CITY OF ALBUQUERQUE

April 4, 2022

Re: Dion's Commissary
4595 San Mateo Blvd NE
Traffic Circulation Layout
Architect's Stamp 10-08-2021 (F17D020A)

SHEET NO. **AS100**  
OF

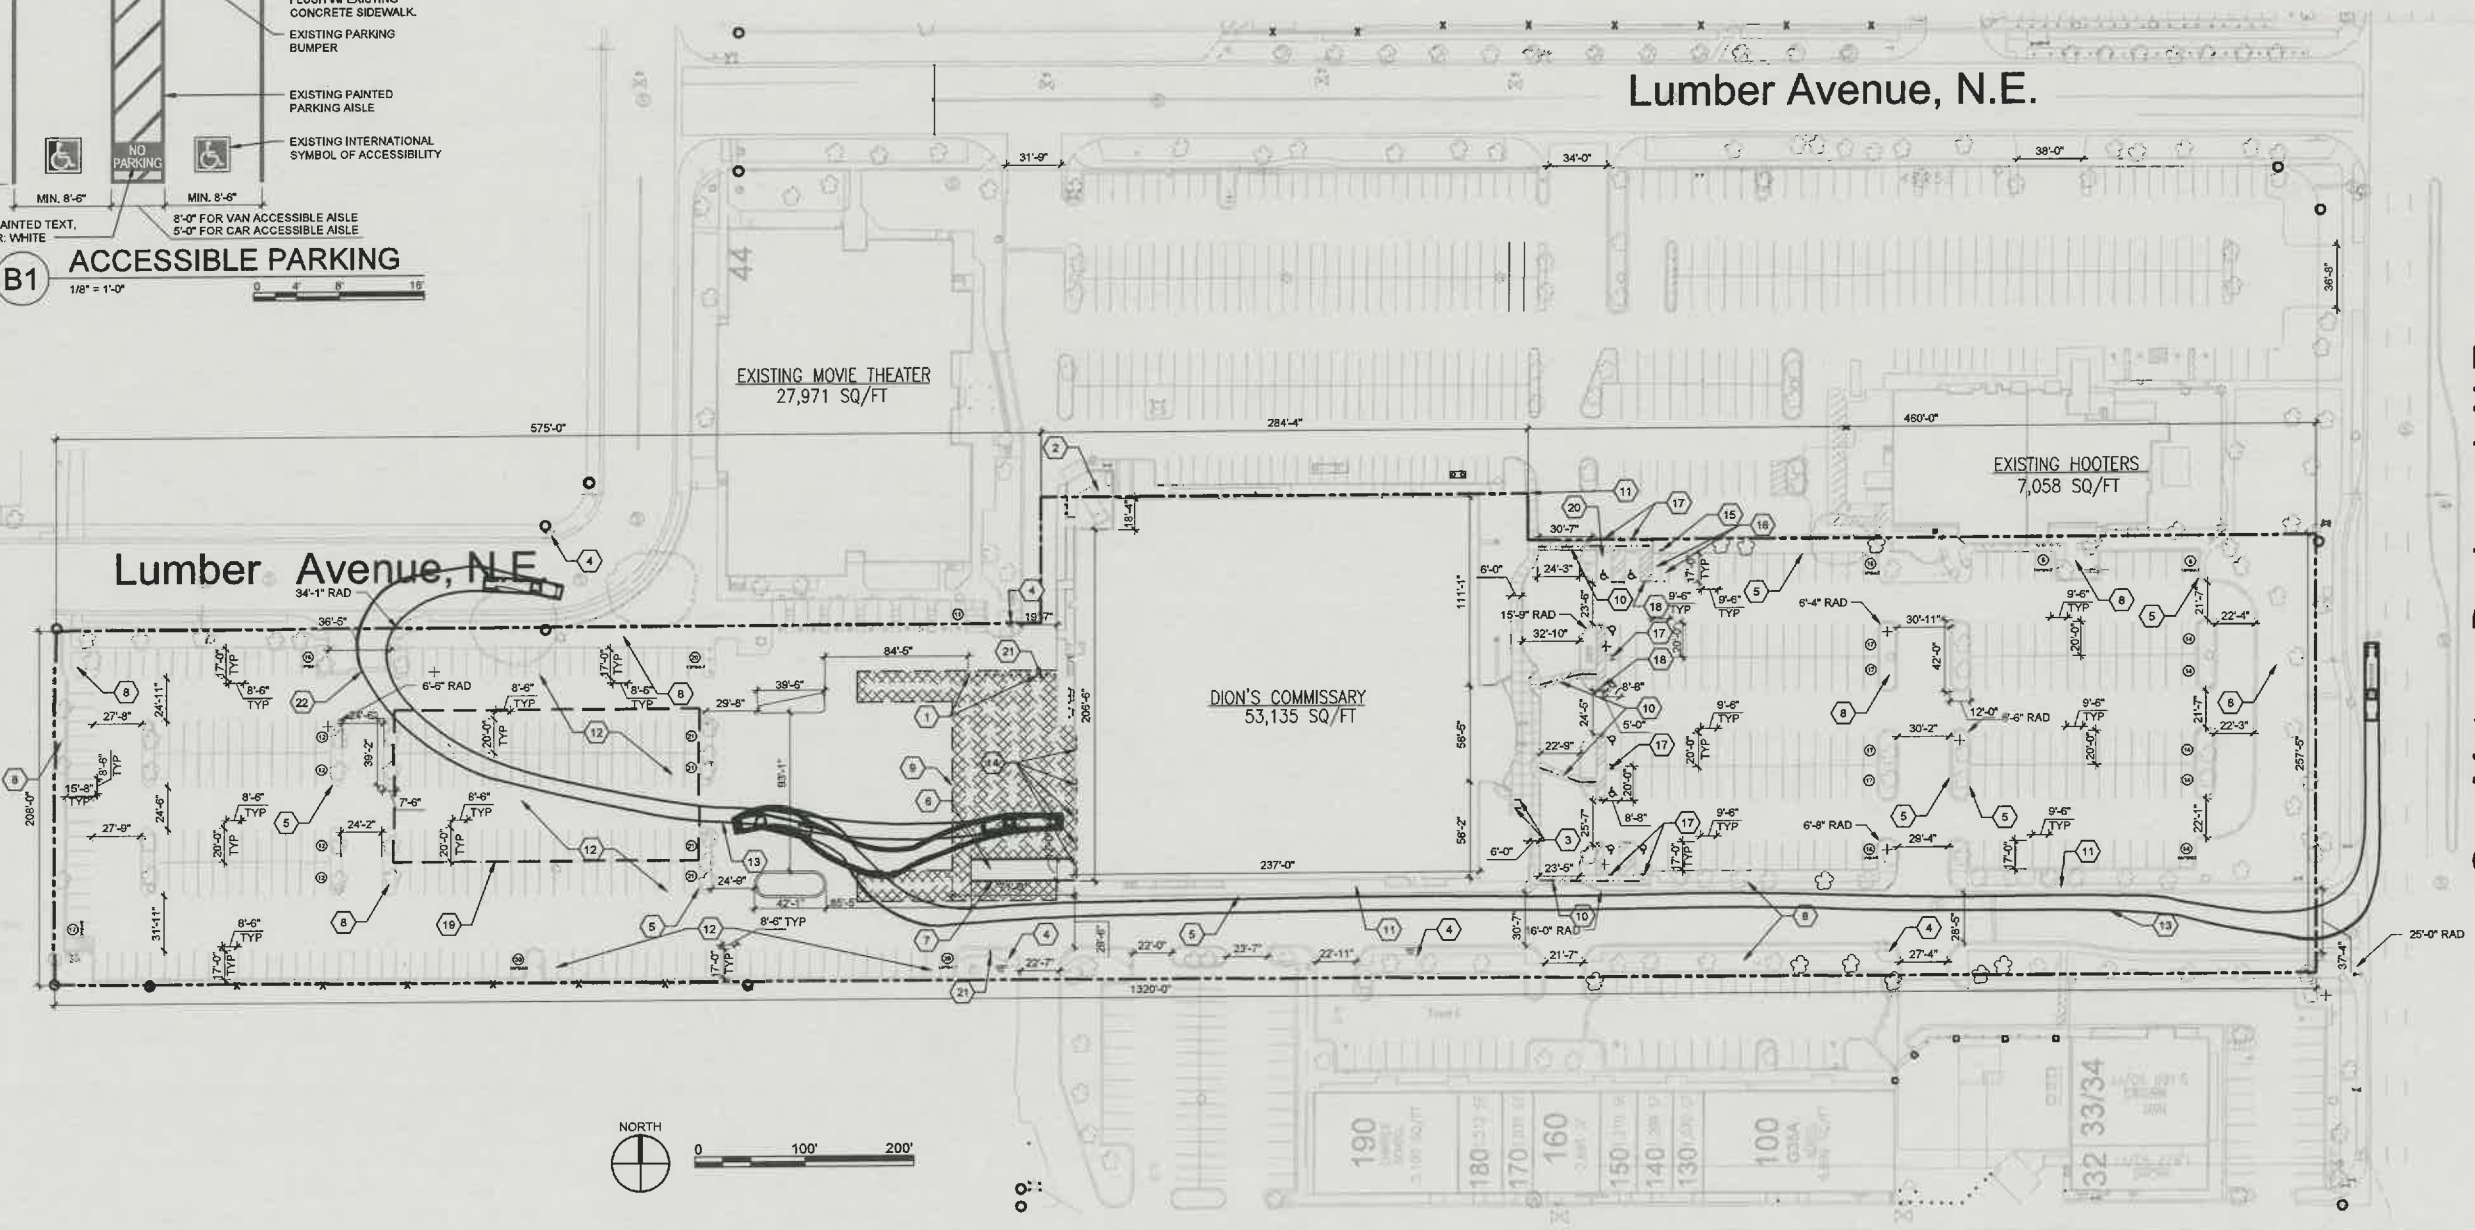
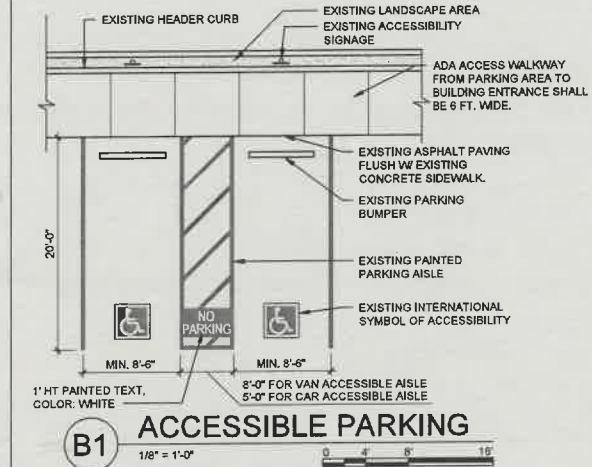
1. Provide the size of delivery vehicle being shown for the turning templates.
2. **Keyed Note 12 and General C:** Explain the type of signage and/or traffic control you will have to discourage vehicle traffic from utilizing the west parking lot
3. Fire Marshal Office: Please provide a letter correspondence from Lt. Brian Barnes stating te a Fire 1 plan is not required (for our files).
4. Please provide a copy of receipt for the resubmittal fee paid (\$75+tax).
